Application for removal or variation of a condition following grant of
planning permission. Town and Country Planning Act 1990.
Planning (Listed Buildings and Conservation Areas) Act 1990

Two storey front extension, single storey rear extension, single storey side extension, first floor side extensions, conversion of garage to habitable use, and conversion of roof space to habitable use to include 2 front dormers, 3 rear dormers and 4 side roof lights, involving raising of ridge height and roof extension, involving alterations to front elevation

27988/APP/2019/3452

The approved drawing no. 1332/P/2B, to be replaced with drawing no 1332/P/2C now submitted.

PROPOSED GROUND FLOOR PLAN - 1:100

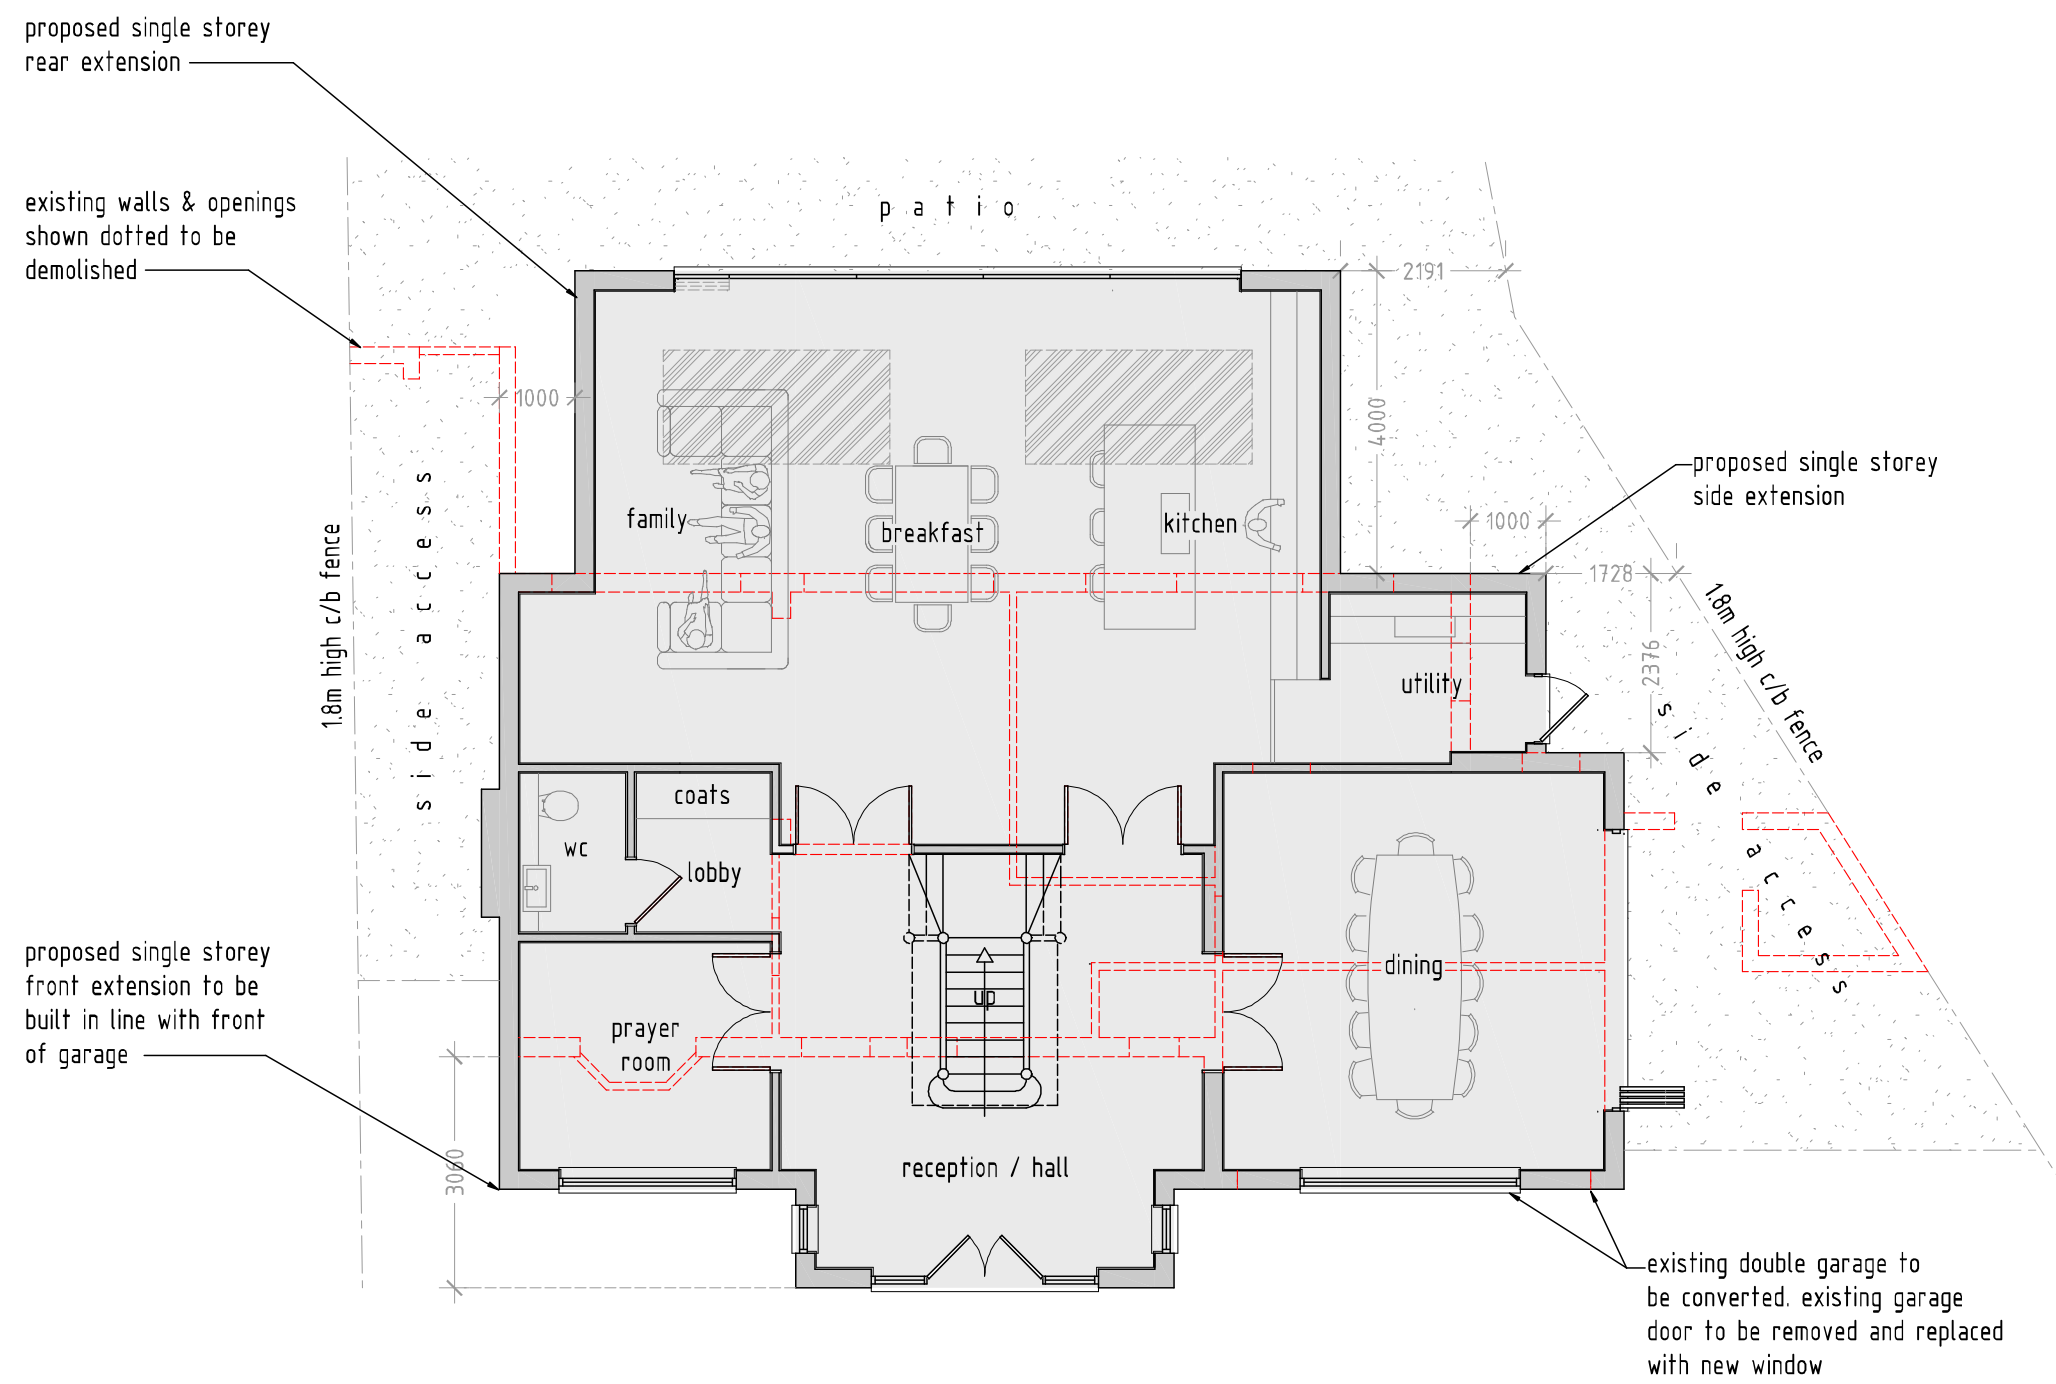
The addition of a front left hand side single storey extension
